**KIRKLEES METROPOLITAN COUNCIL
INVESTMENT & REGENERATION SERVICE**

Reference No: 2020/62/92351/E

Site Address: Batley Police Station, Market Square, Batley, WF17
5AA

Description: Change of use of former police station to 9 apartments
with associated works (Within a Conservation Area)

Drawing:
PROPOSED FLOOR PLANS

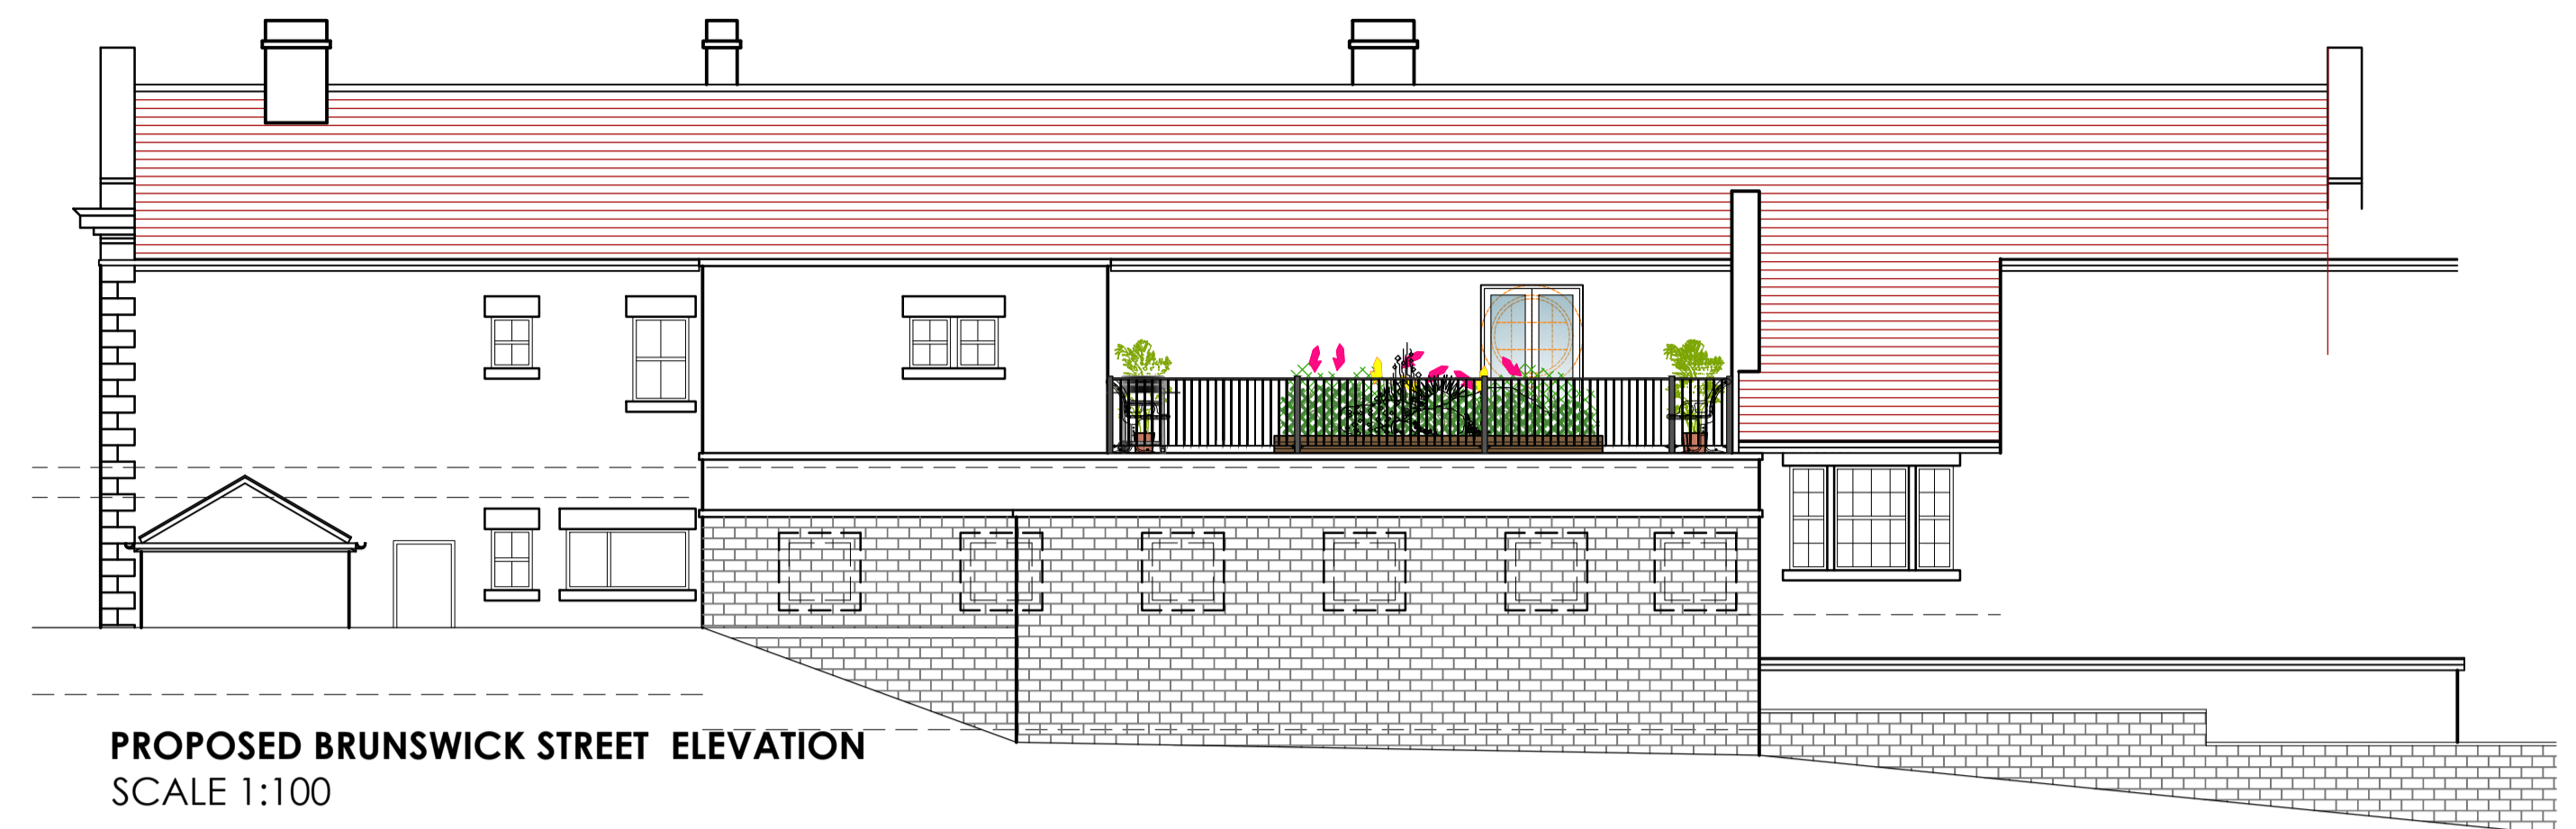
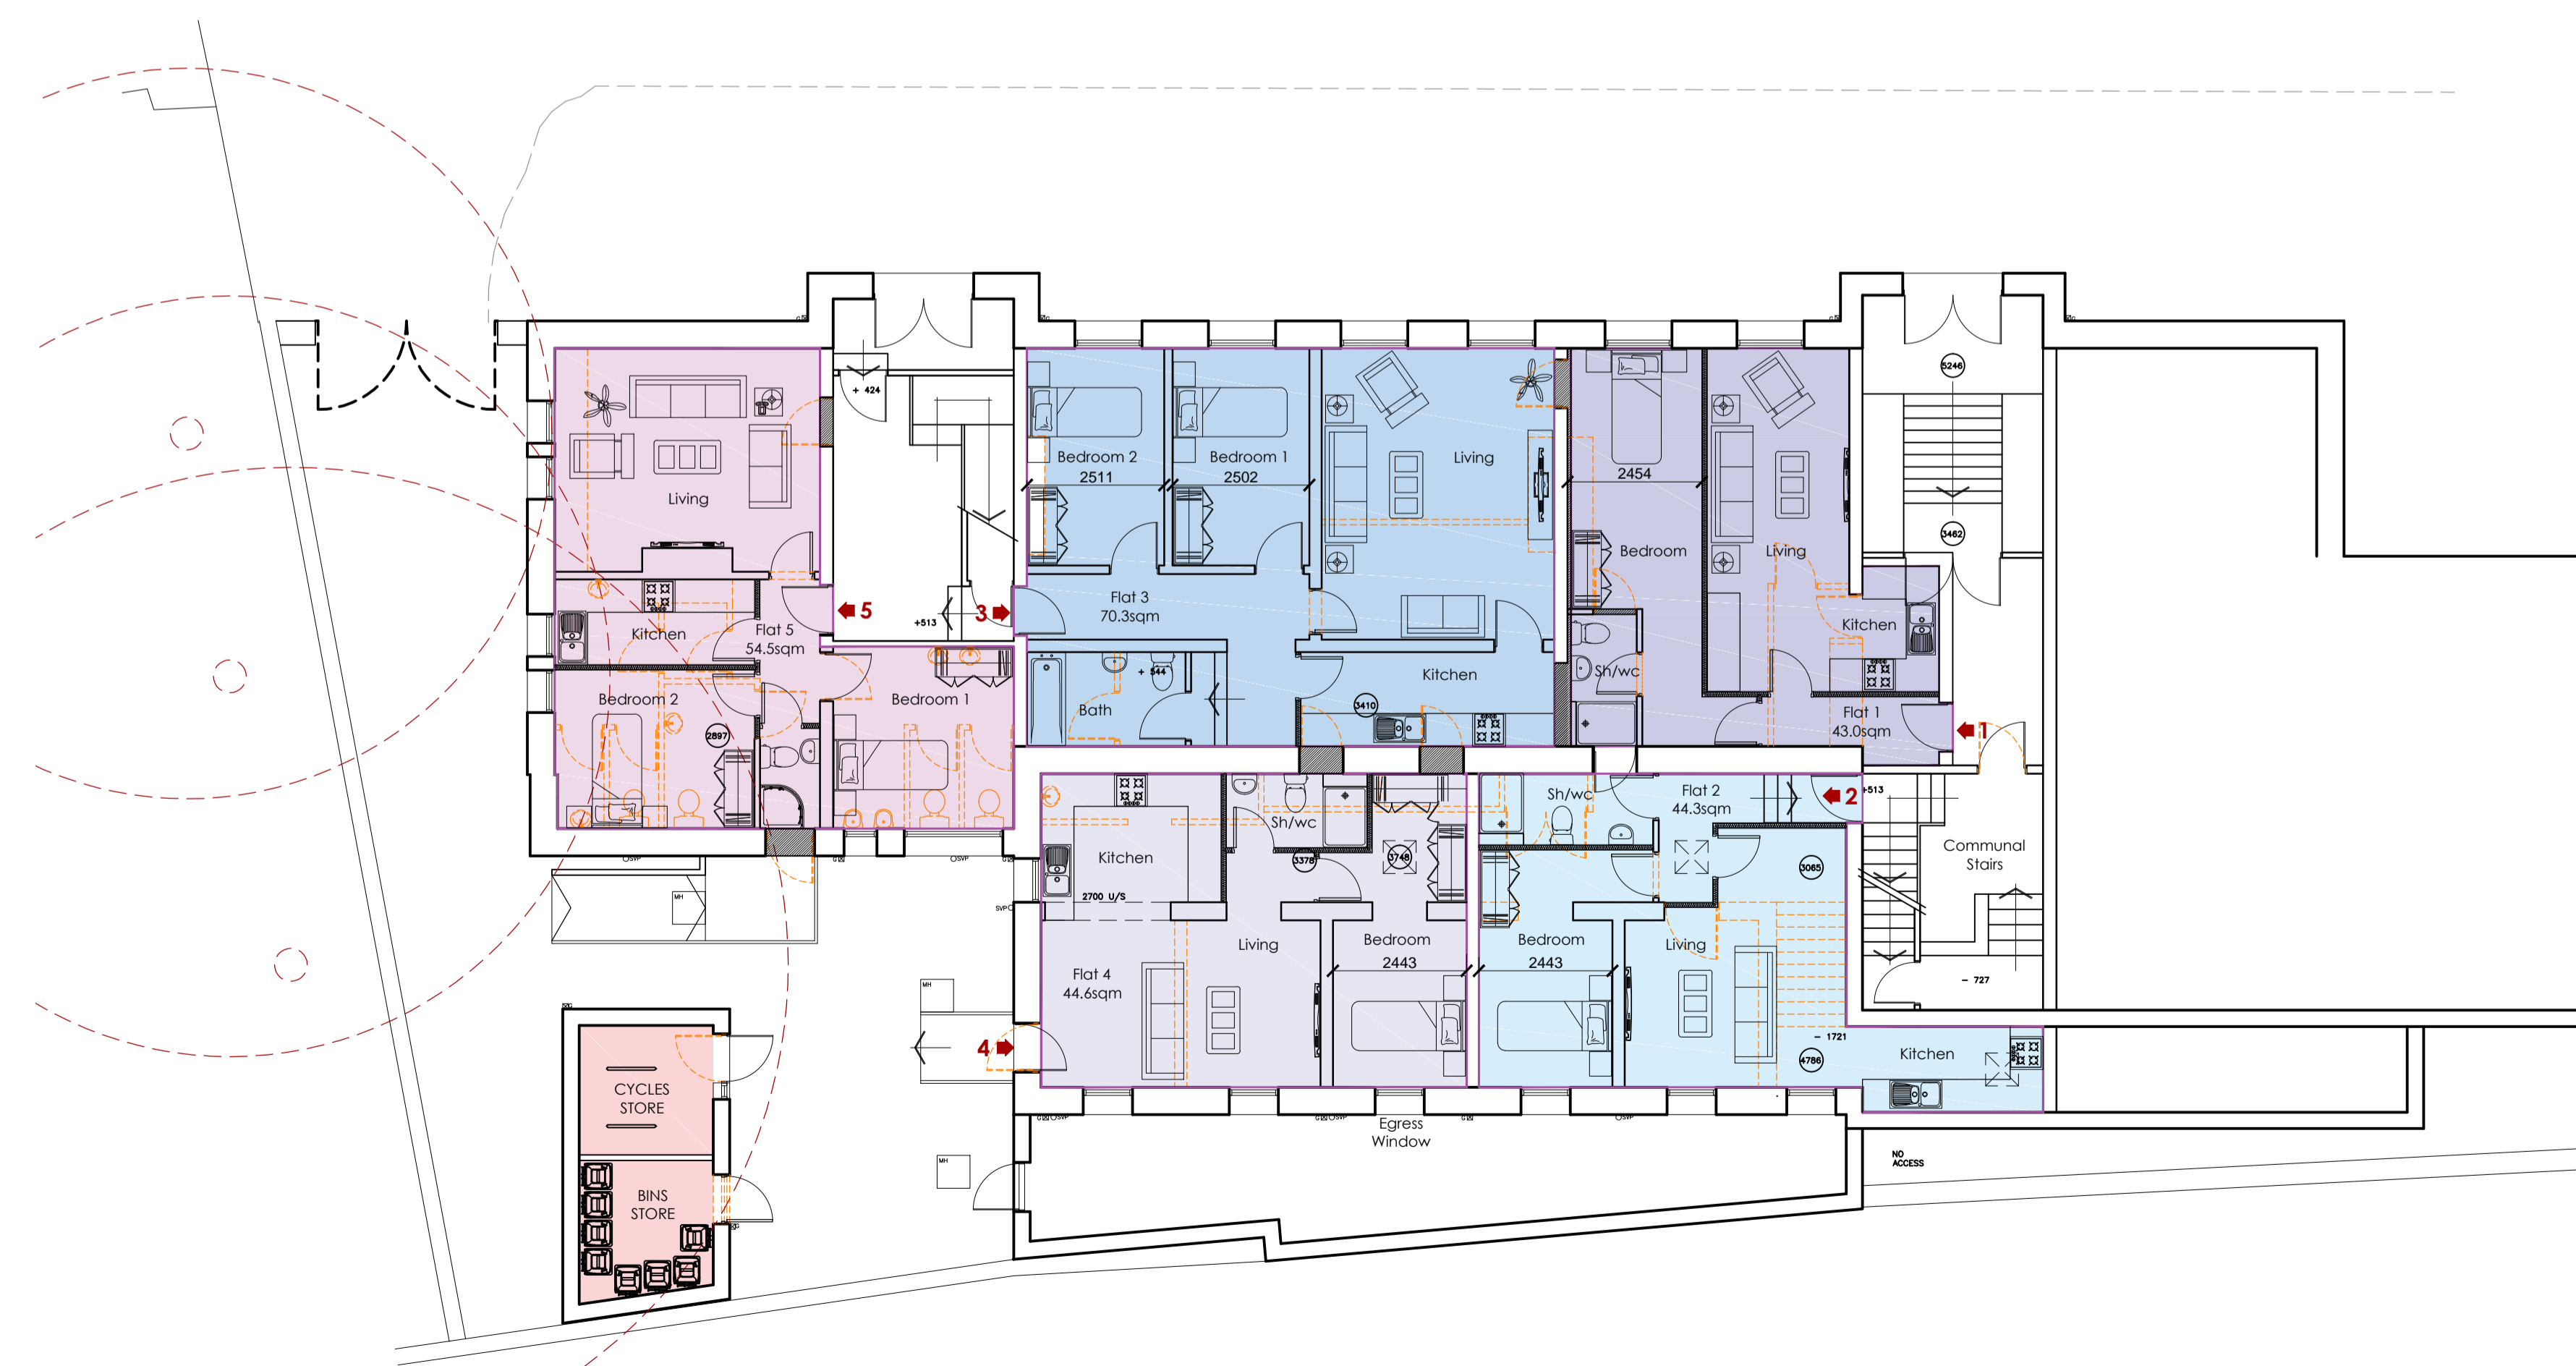
The terrace element of the proposal is to the rear of the main building and would not be overly visible from the main aspect of this building. The terrace is small in scale and would complement the main building by virtue of its minor impact on the appearance of the rear elevation – the railings are black and in keeping with other railings in the area. The openings would remain as existing, apart from changes to facilitate access onto the balcony. The openings are of a similar design and of an appropriate scale to retain the character of the building and replicate the existing openings. These changes will be captured in condition 2 of the decision notice.

However, Highways DM did refer to cycle storage, stating it should be provided on a plan and that the bin storage area is not to the required standard and no collection point is provided. The agent subsequently submitted a plan addressing these points, which is considered acceptable.
